Document Title	Date	Revision
RtS 4 Supplementary Response Drawing Change Register	03/05/2019	01

Concept Proposal - Change Register

SSD2 Stage 1 DA Drawings - Change Register**AR-SKE-10-110 – Revision 03**

AR-SKE-51-001

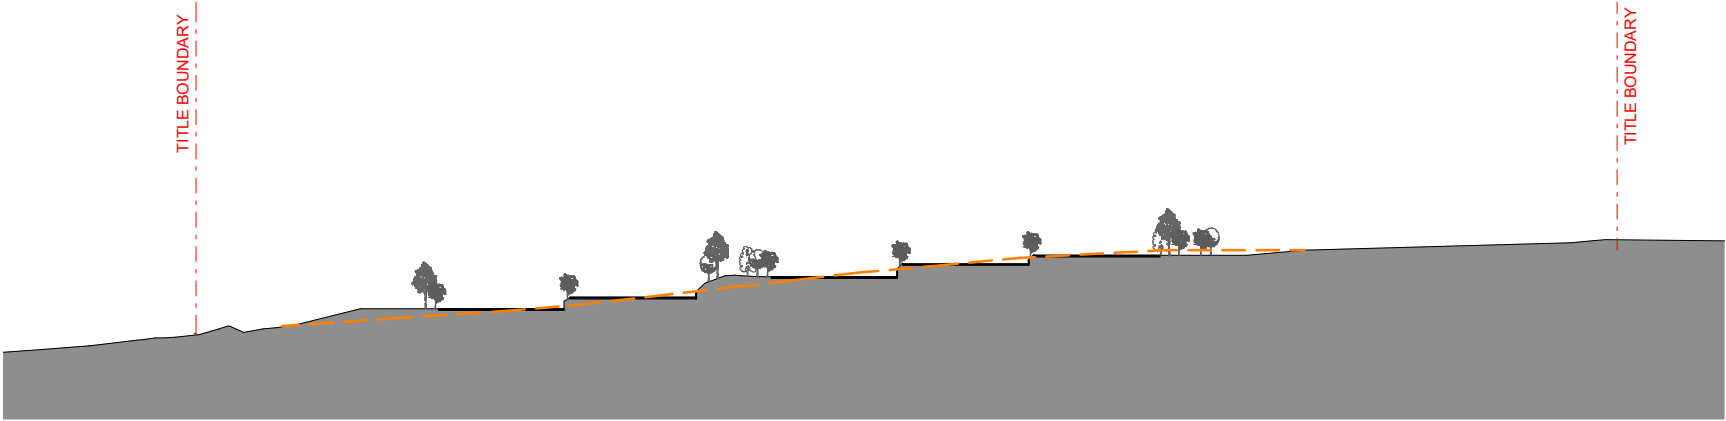
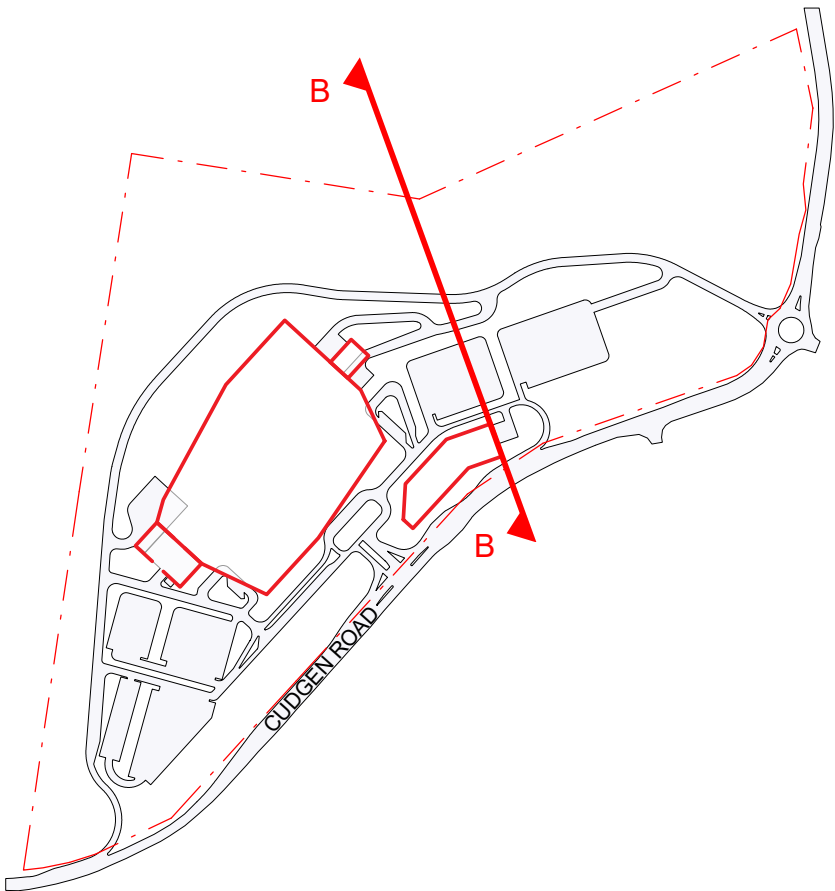
- Key Plan updated
- Health Hub envelope removed as not relevant to this drawing

AR-SKE-53-101

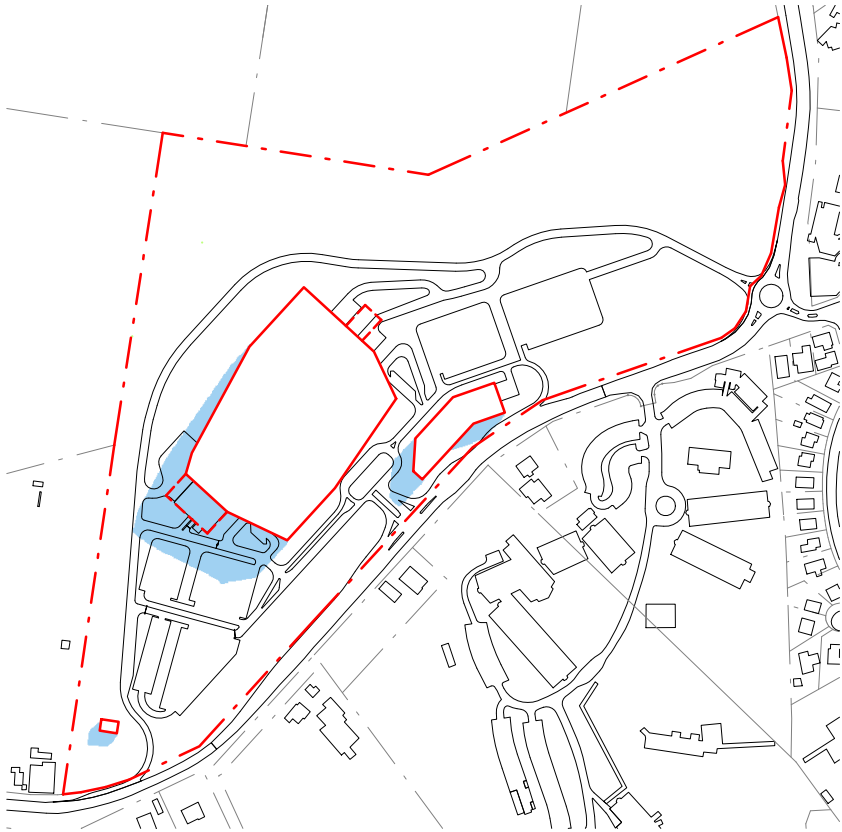
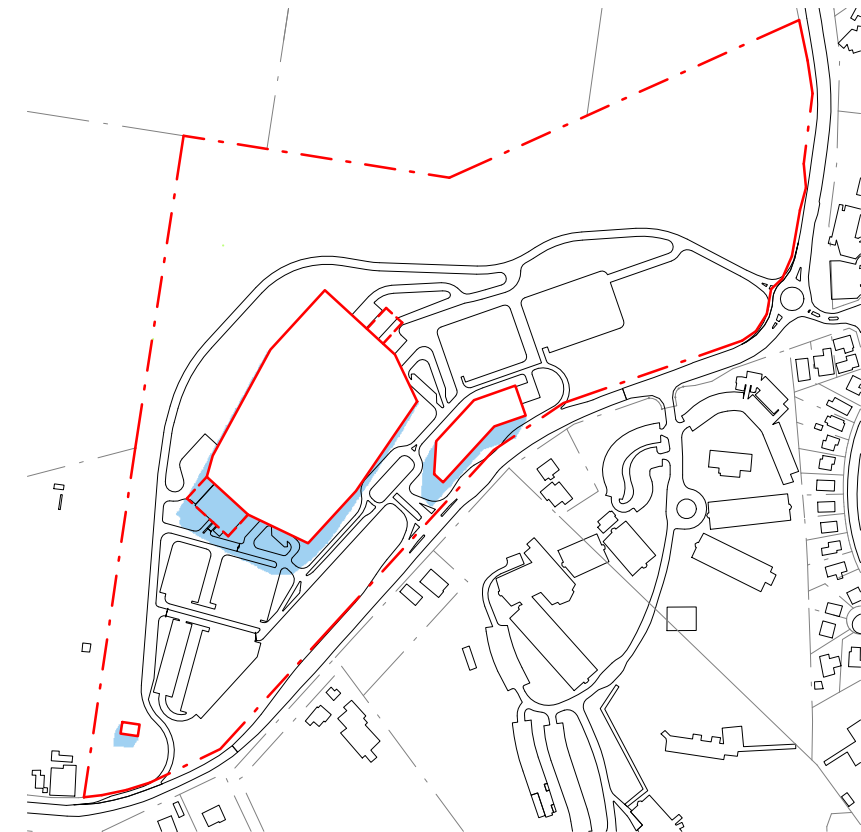
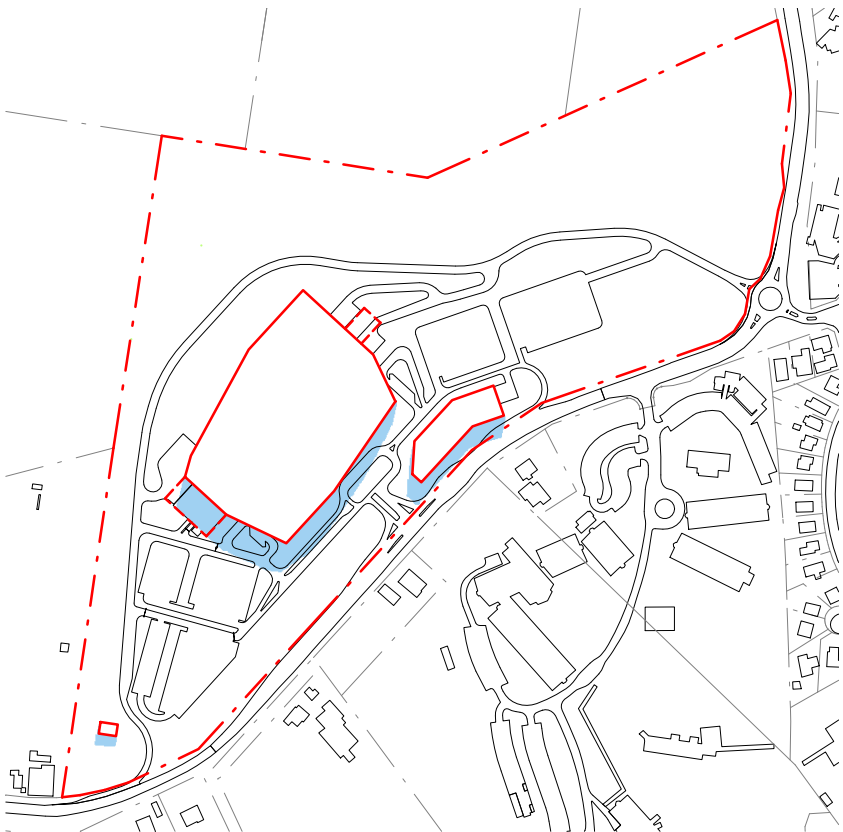
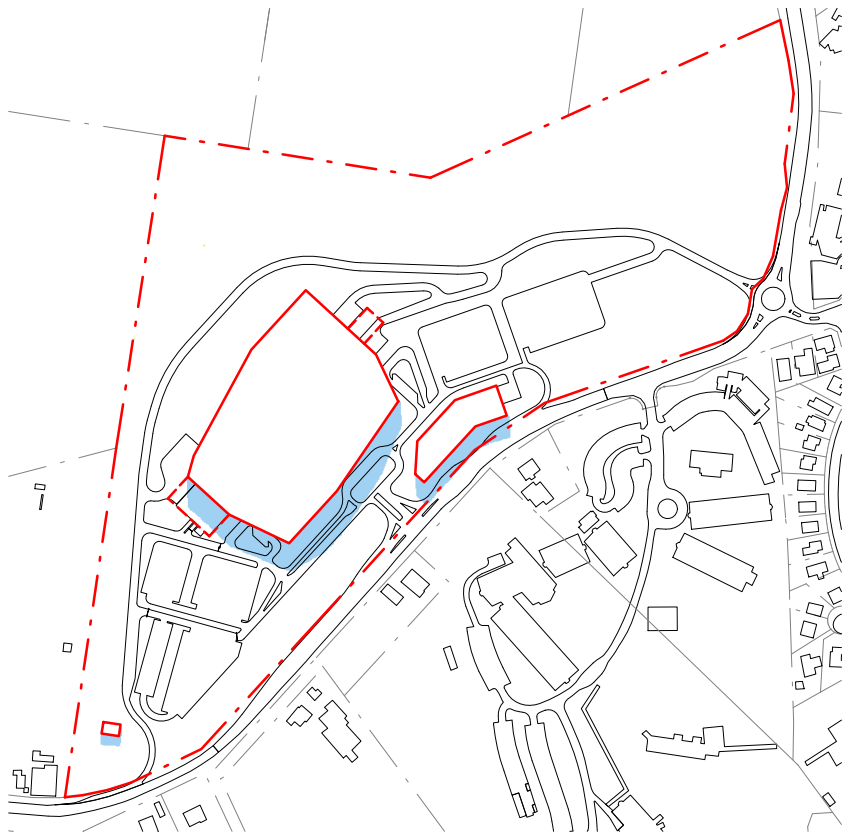
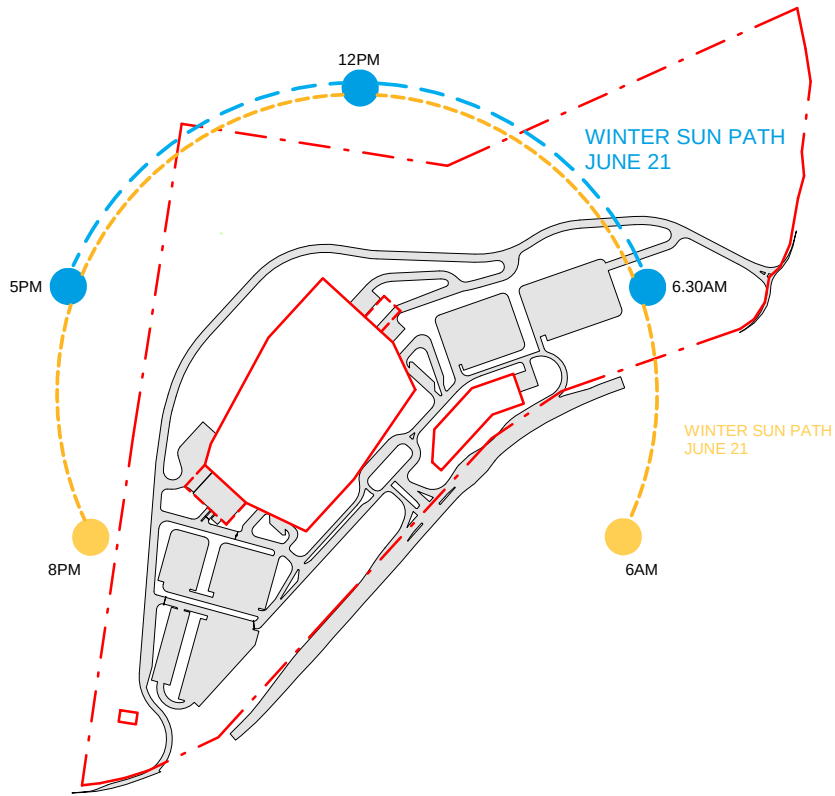
- Maximum Planning Envelope (MPE) location and geometry revised
- Roads/Carparks updated to reflect revised location and geometry of MPE
- Shadow studies updated to reflect revised location and geometry of MPE Maximum Planning Envelope (MPE)
